DECISION DELEGATED TO HEAD OF PLANNING

Application No: H11-0485-24 **Applicant:** Mr L Shepperson

Proposal: Residential Development - approved under H11-0174-23. Modification of Condition 2 to allow amendments to approved plans and Conditions 4 and 5 relating to Flood Risk Assessment and Landscaping

Location: Adj. 17 Trafalgar Square Long Sutton Spalding

J192-PL 1B

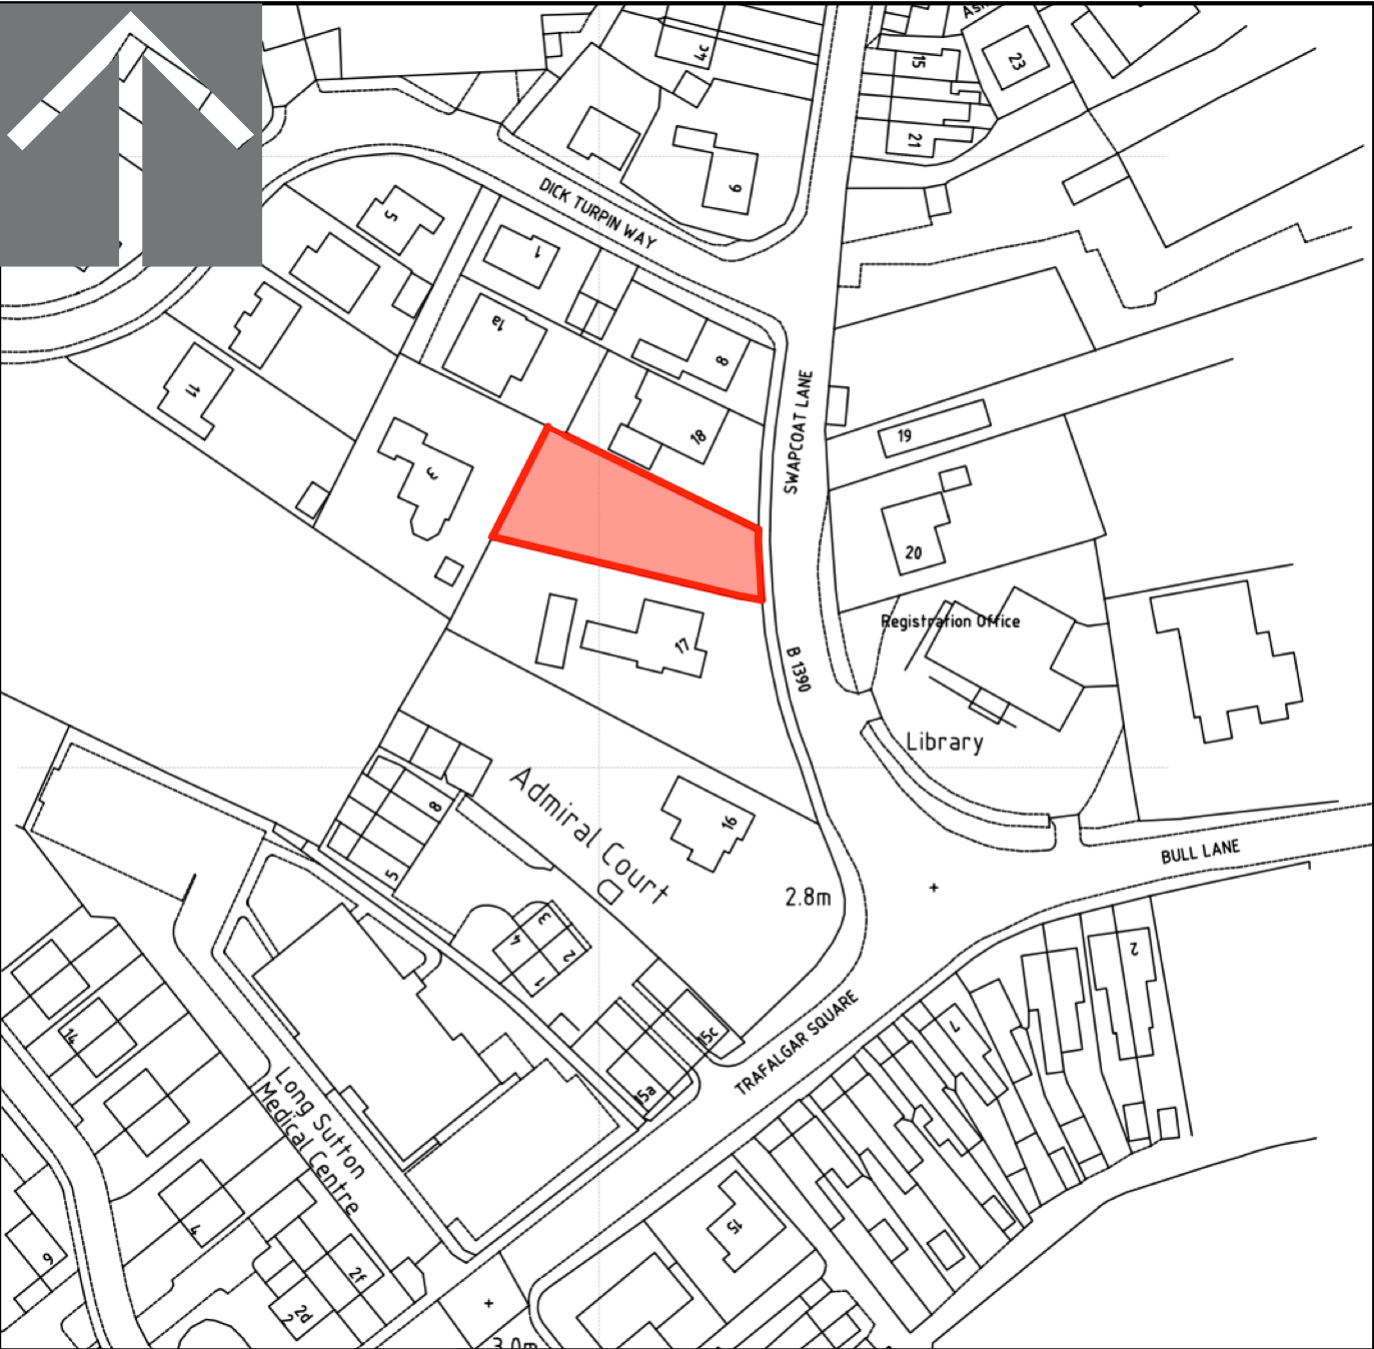
main footprint of the dwelling, including its width to allow for an integrated garage. The proposed detached garage is also removed from the plan. The proposed plans also show soft and hard landscaping.

J192-PL 3D

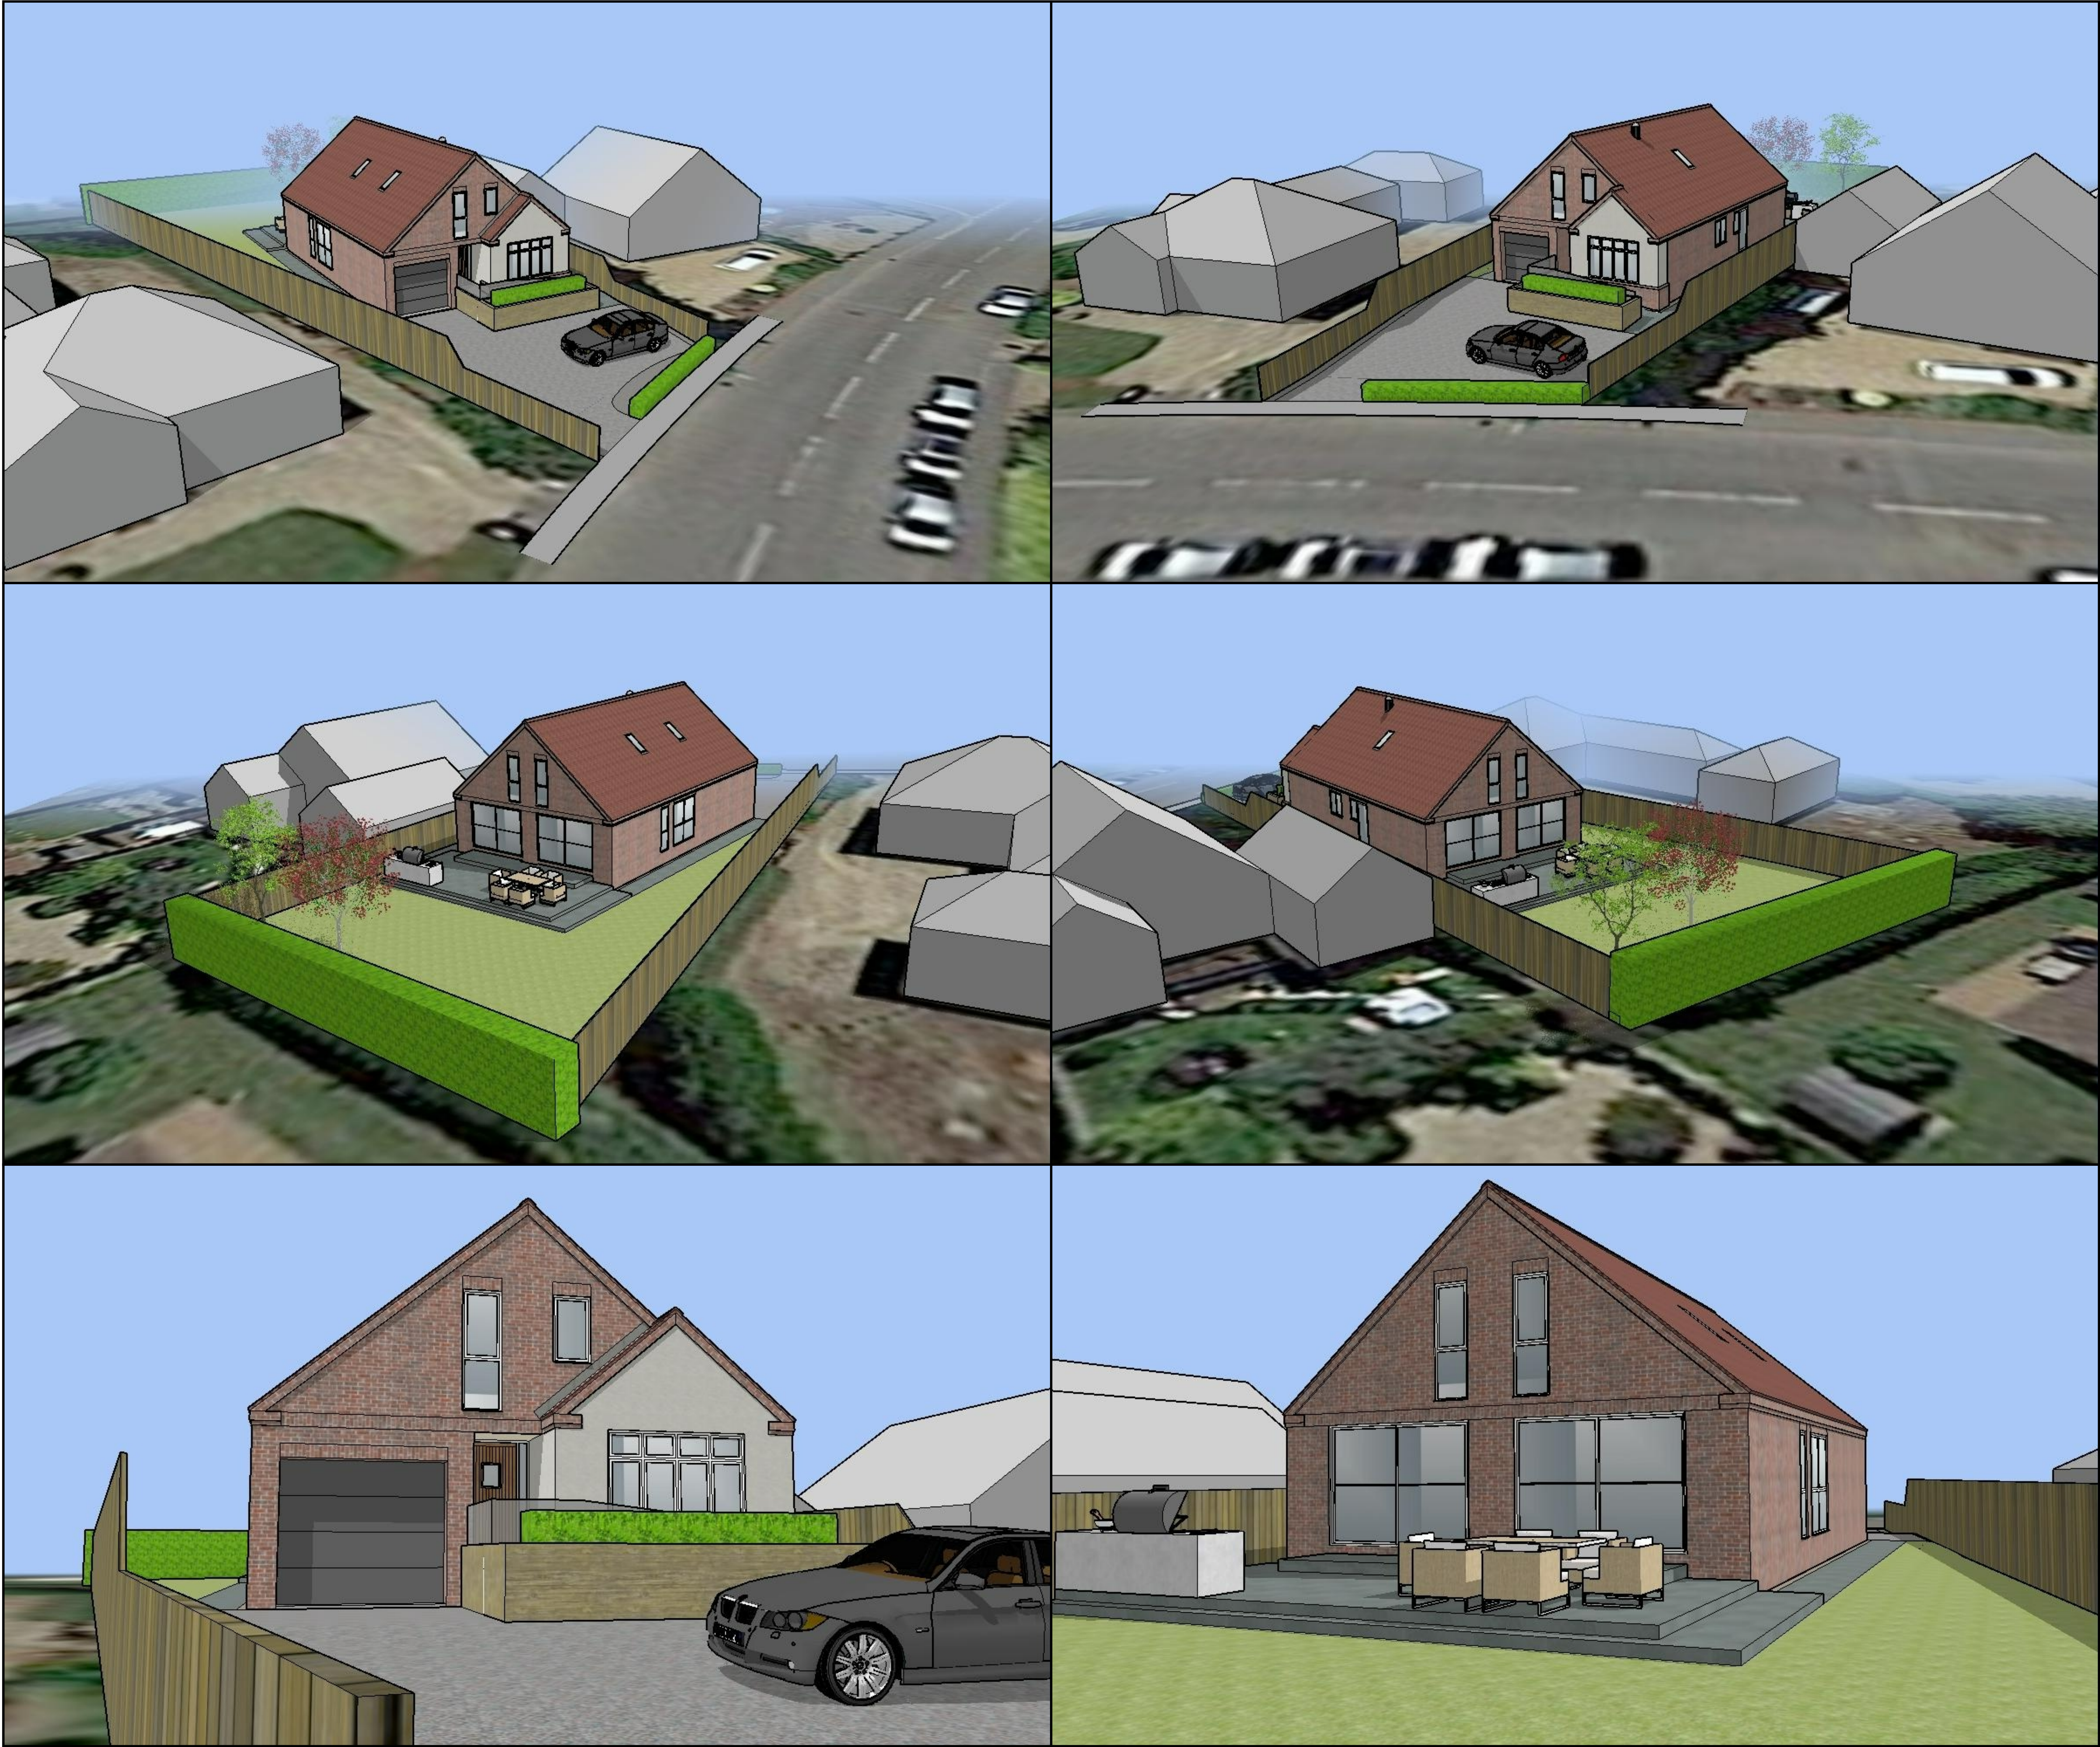
In terms of overlooking given the need to increase the finished floor levels 1m above existing the side openings need careful consideration. The upper floors are served by roof lights and impacts from these are considered acceptable. However, a door that serves the utility room to the north side elevation along with a window serving the study are likely to result in the ability to 'look across' the side of the neighbouring dwelling (number 18) this is because the proposed 2m boundary fence is halved in its effect upon reducing overlooking. Therefore, a condition will be attached that these opening are to be obscured will be attached. Furthermore, should a ramped access be proposed or a platform outside the utility door, it shall first be agreed in writing with the LPA, such a structure would also be required to provide a privacy screen to prevent any unacceptable overlooking.

To the opposite side an opening service the hallway and one serving the snug will also be required to be obscured. The snug has other openings serving the room and the hallway does not represent primary living accommodation.

The applicant has provided alternative resilience measures in an attempt to remove the requirement for finished floor levels to be sited 1m higher than external ground levels (this is secured via condition on the extant permission). Given that the requirement in relation to floor levels relates to EA standing advice, the EA have been consulted. The EA's initial response was that condition were not imposed by them under the previous approval and to refer to standing advice. The second set of comments does make an assessment of the proposed mitigation measures and does not consider them to be sufficient to remove the flood risk.

Subsequently amended plans have been received from the applicant showing that the dwelling will be sited at 1m above existing ground levels, this replaces the resilience measure put forward. This will be reinforced through planning conditions. The EA have confirmed that this would remove their objection.
